Civil Engineering Services, PC (CES) is in receipt of your comments. Below are our responses to your comments. Please include this document in your review of the proposed development engineering plans.

PANDA EXPRESS

2040 GIBSON BLVD SE
ALBUQUERQUE, NM 87106

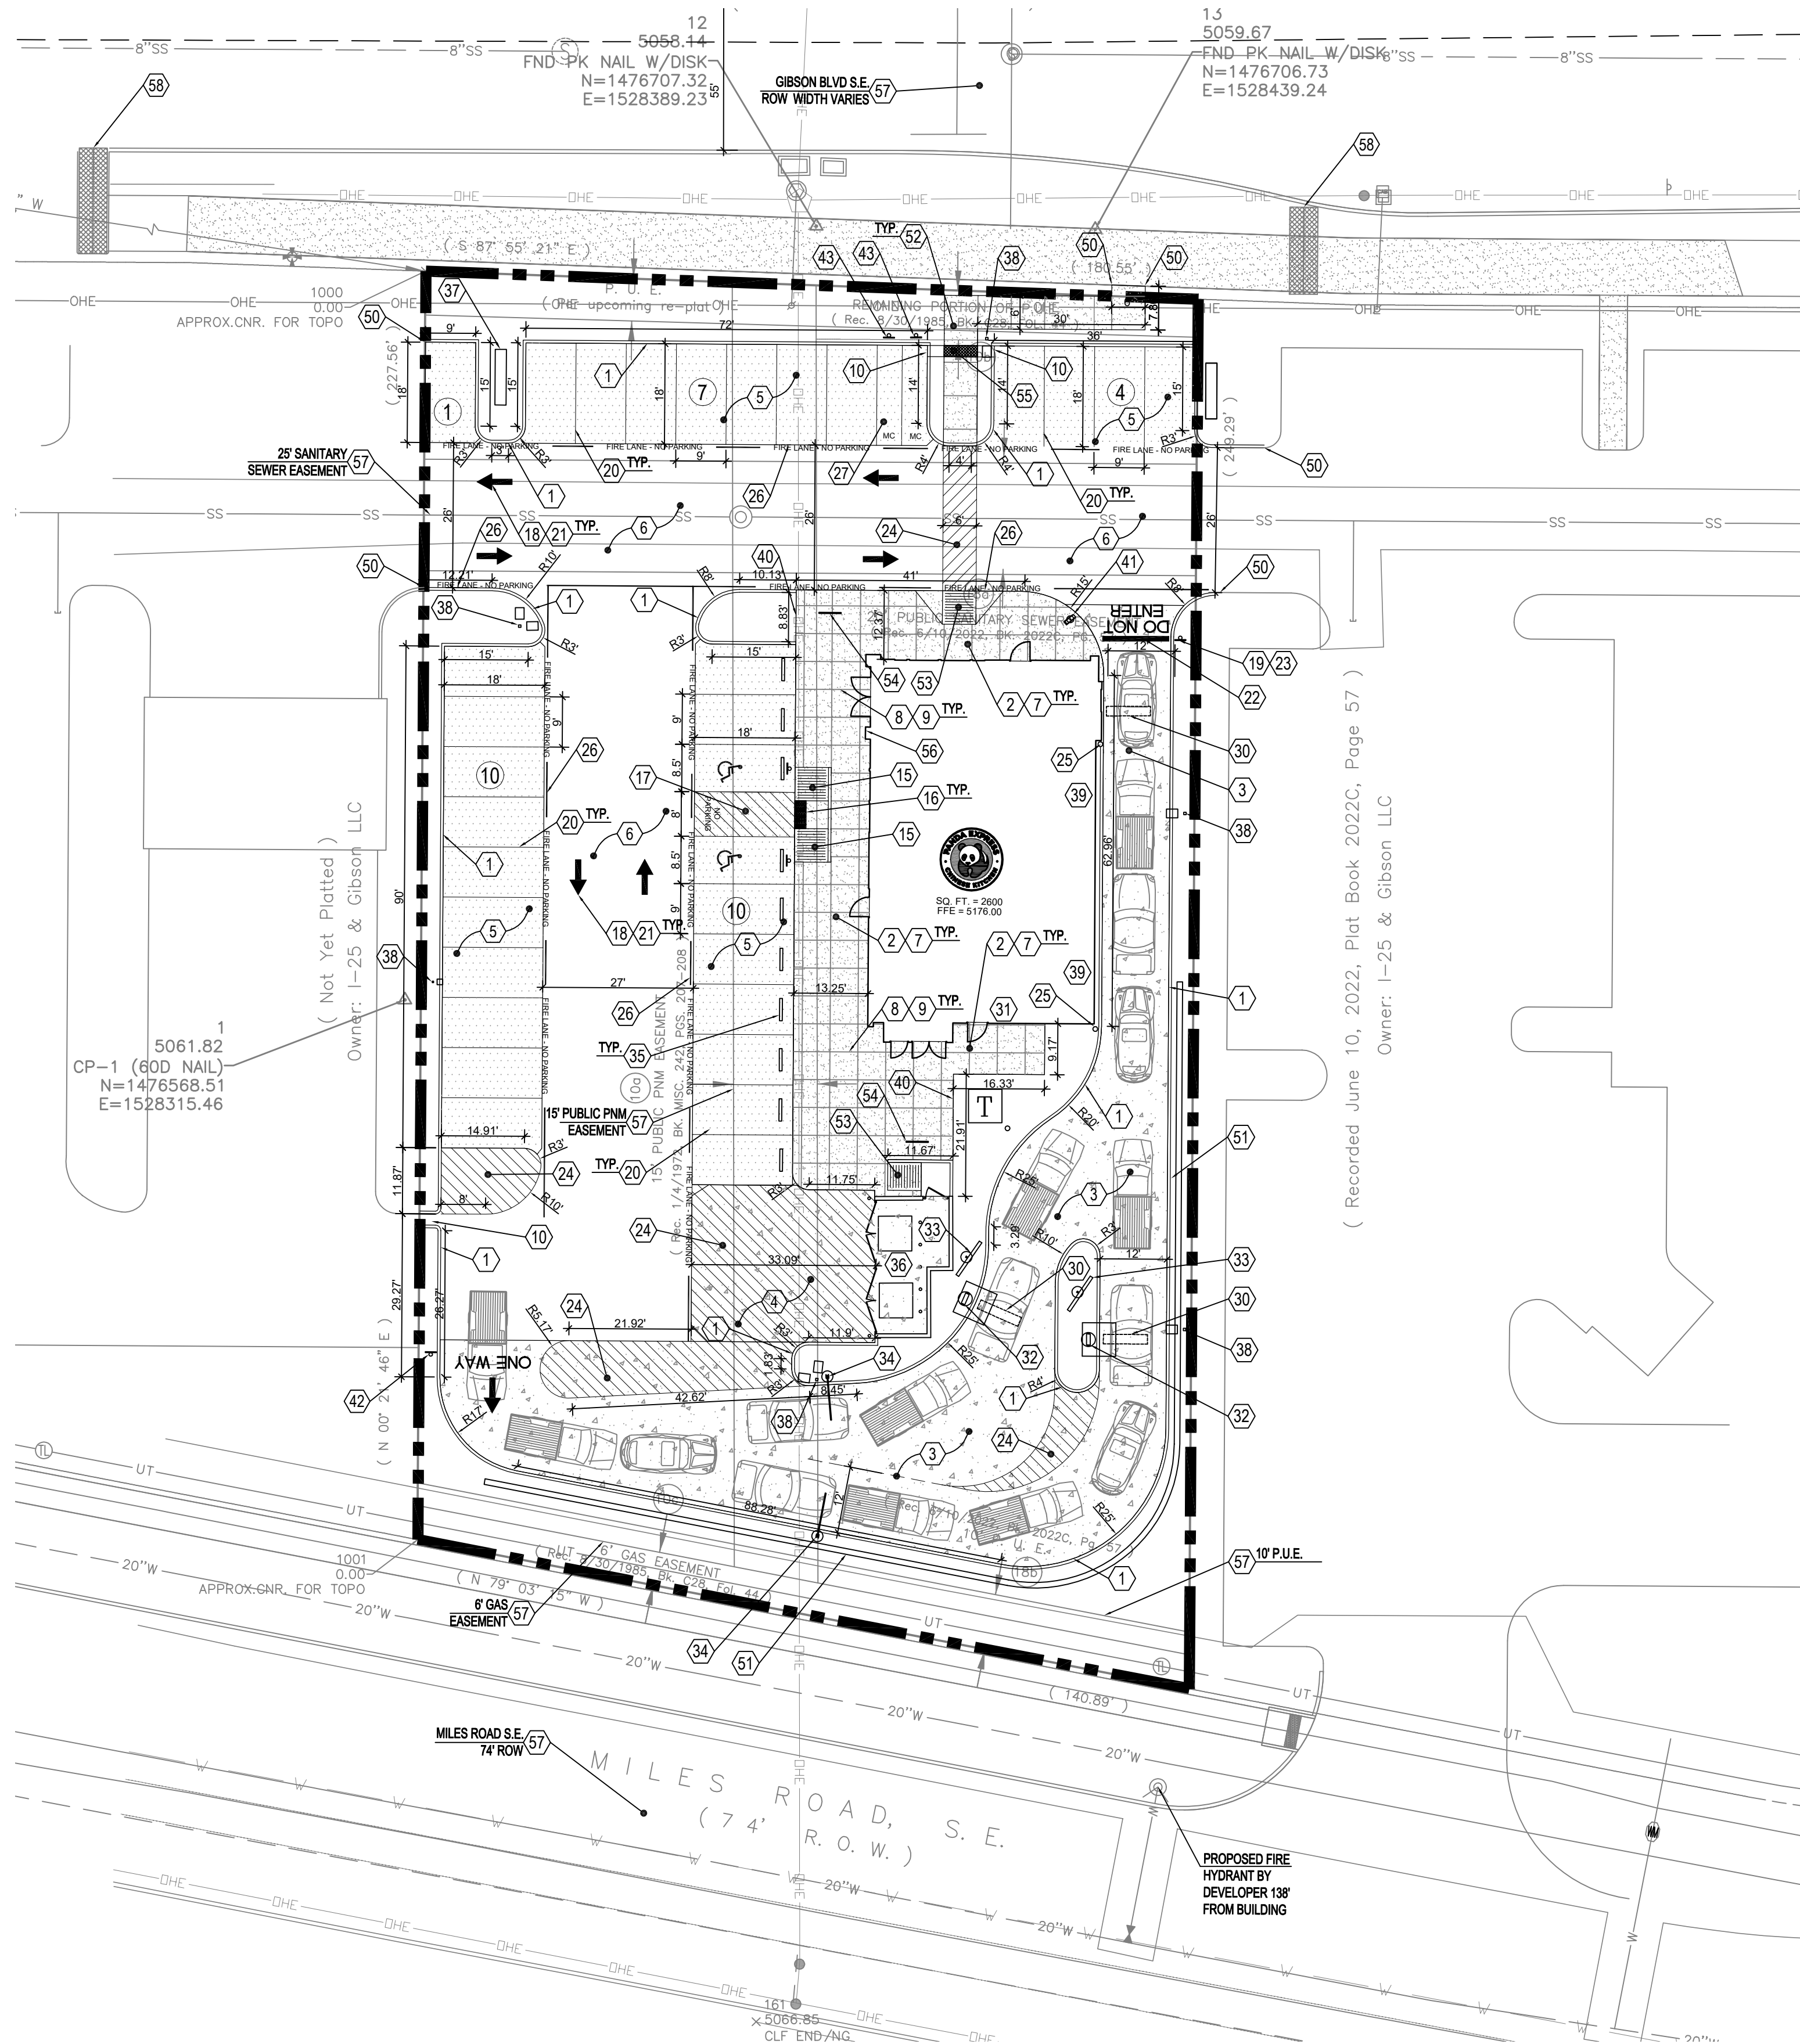
3. This access doesn't shown on the approved plat.

Response: This access has been removed, see Site Plan C03.0.
